From: [Kendal](#)
To: [A585 Windy Harbour to Skippool](#)
Cc: ["A585WindyHarbourtoSkippool@highwaysengland.co.uk"](#)
Subject: A585 Windy Harbour to Skippool - Our Clients Messrs Ditchfield
Date: 03 October 2019 09:33:41

| Drawing Title | ENVIRONMENTAL MASTERPLAN SHEET 13 OF 32           |  |

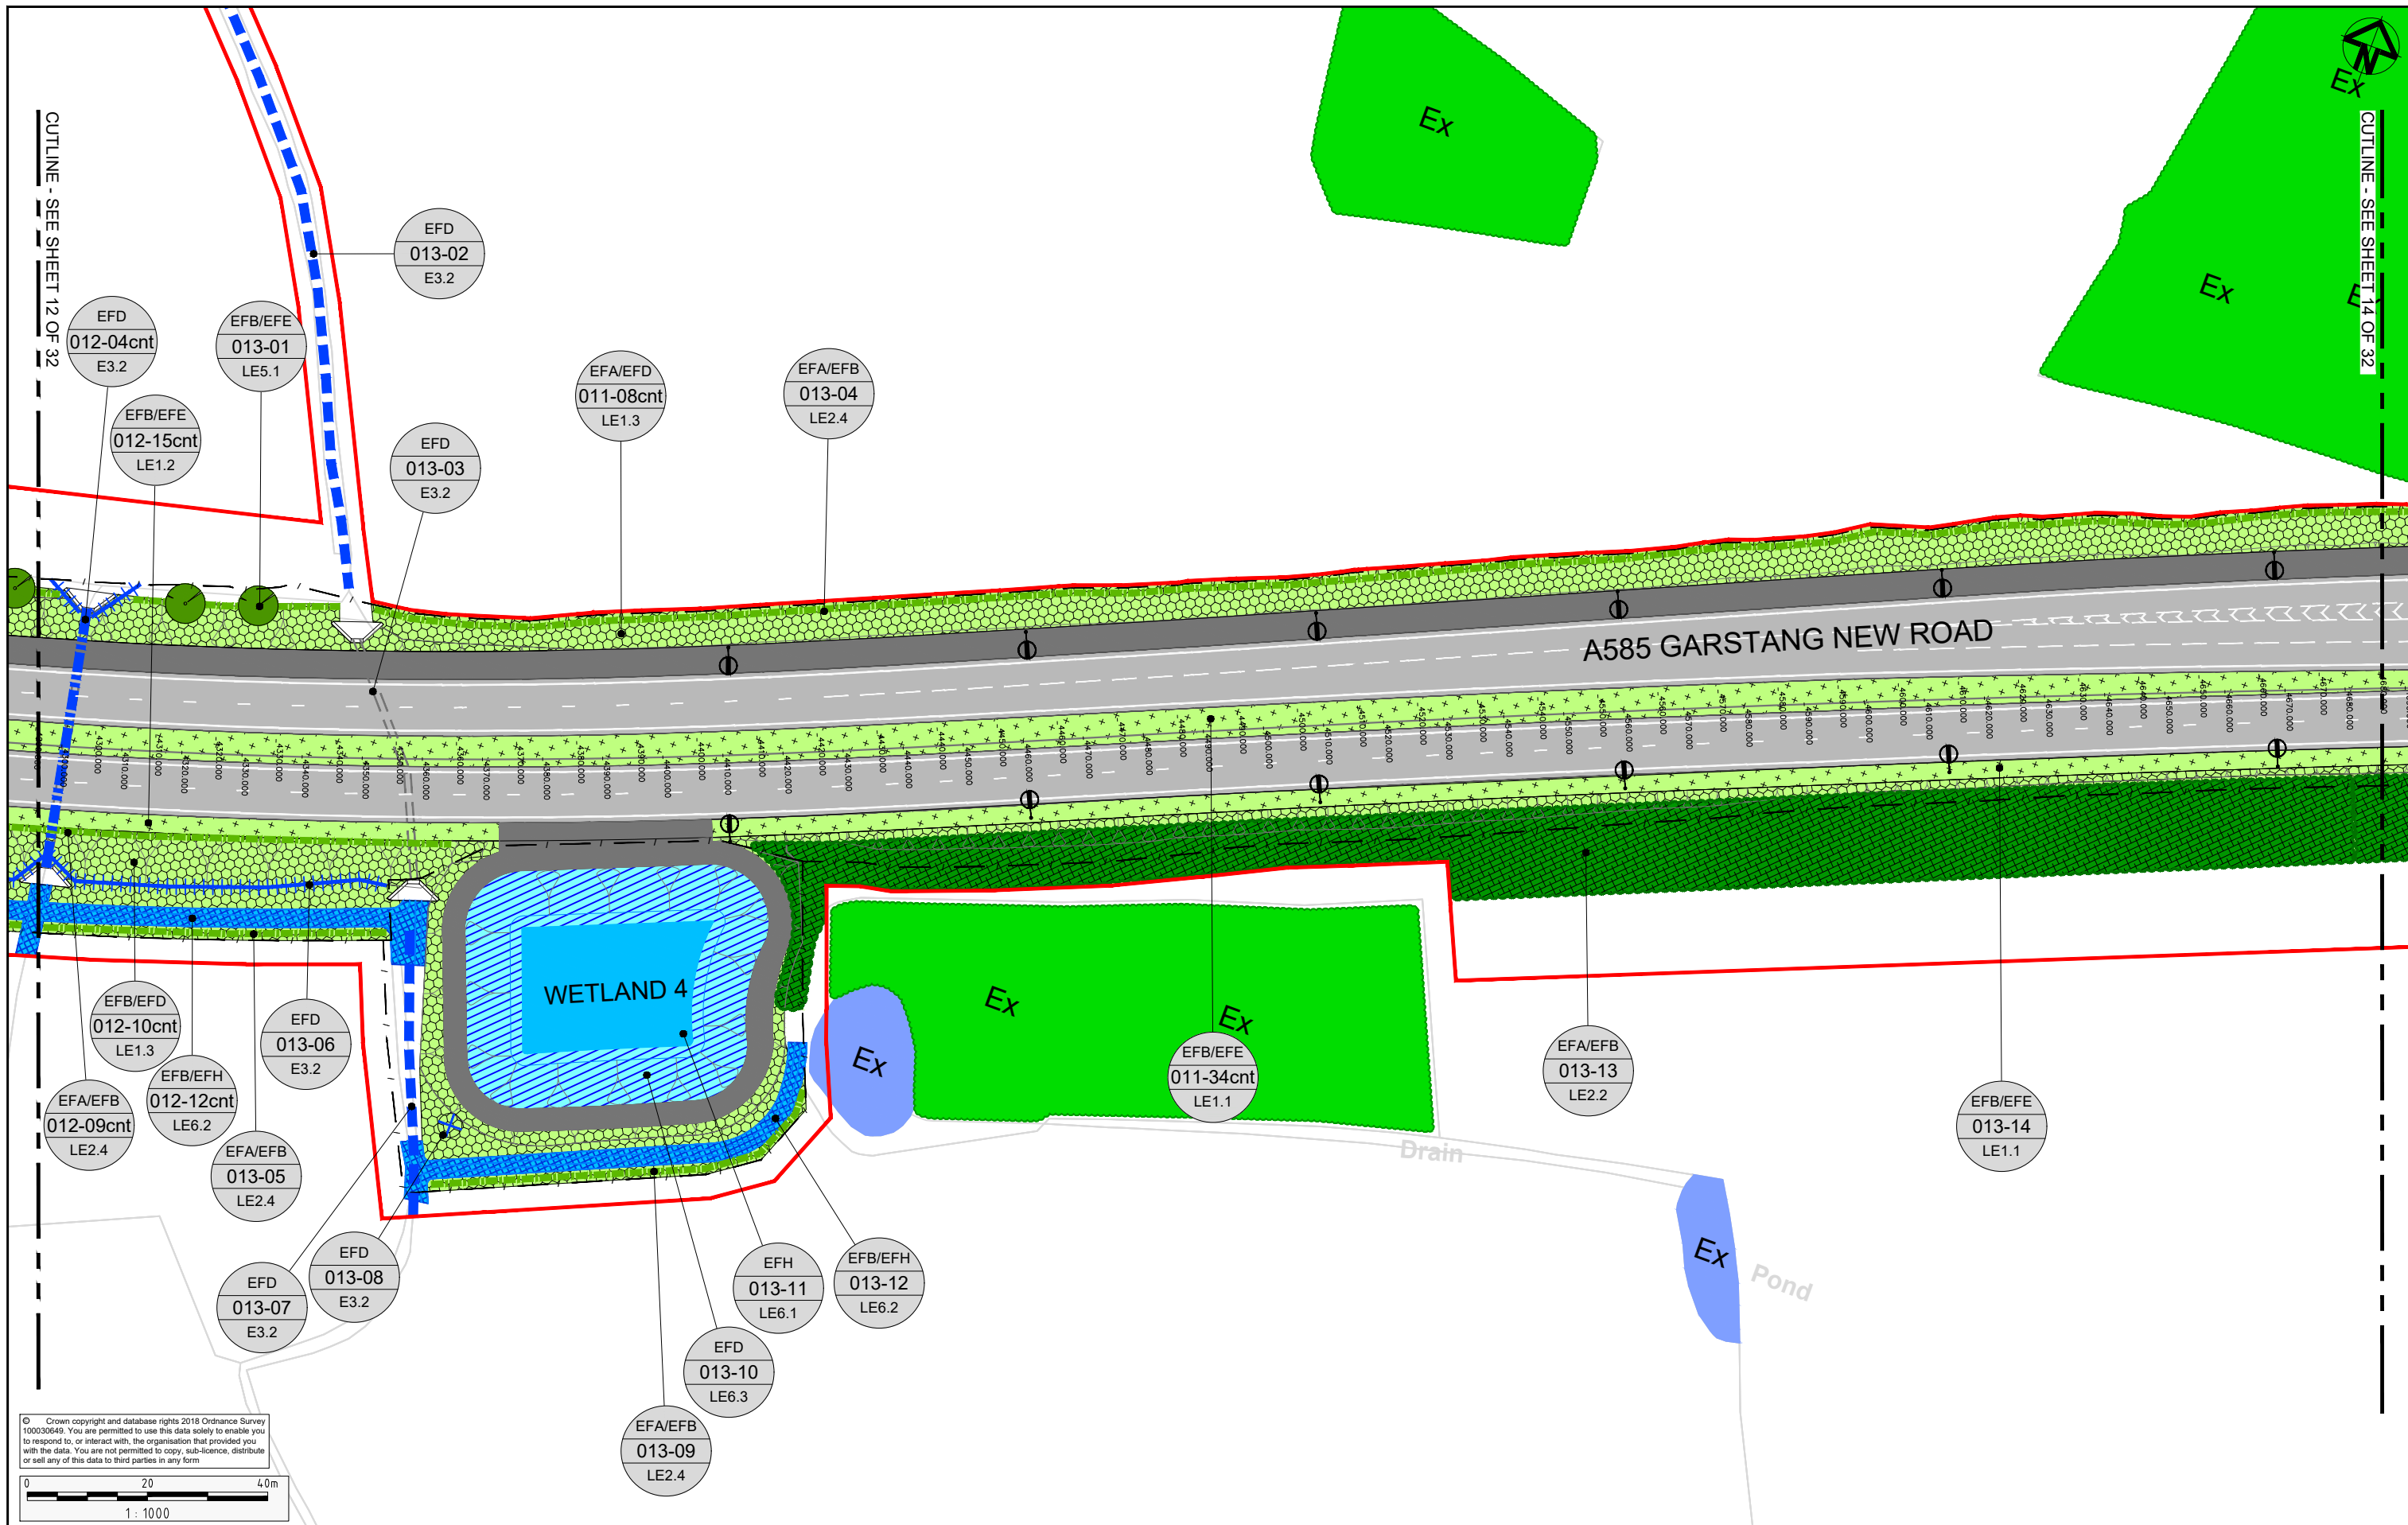
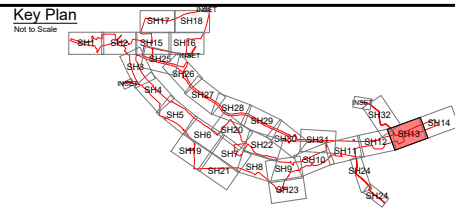
We refer to the above and following recent discussions with representatives from Highways England we can confirm that we have still have outstanding queries regarding the temporary land use area on our clients land. It would appear to us from the Environmental Master Plan sheets 13 and 14 that a substantial part of the area which is required for temporary use is in actual fact going to be planted to woodland edge. We are unsure as to what exactly woodland edge involves and have asked for clarification. Clearly this gives the impression that although the land is required temporarily it may well be that it is used in such a way that it can no longer be returned to its former use once it is returned to the land owner. We would query whether this is in fact a temporary use of land.

We have also noted that in the responses to representations received at deadline 6 and 6A being document 7.28 under paragraph REP6 – 024 – 2 that the applicant has indicated that the temporary working area is required for 2 purposes the first being for the installation of the new highway boundary. We question why such a large area is required for such a simple task which should only require an extra 1metre to 2 metre to the side of the boundary. In this particular case the working area appears to be some 20 metres to 30 metres wide. The second purpose is to carry out planting to mitigate the loss of vegetation and enable early planting of new trees ahead of landscaping. Whilst we are quite happy to consider the early planting of new trees ahead of landscaping we fail to understand the further comment that the applicant could reduce the extent of temporary land required to align with the environmental master plan (which reflect a smaller footprint of landscape planting), however this would result in no early planting of woodland ahead of the main works. We are completely at a loss to understand how permitting early planting would extend the area required unless it is simply a case of they are seeking to extend even further the area and it would be an area in addition to that shown on sheets 13 and 14 of the environmental master plan.
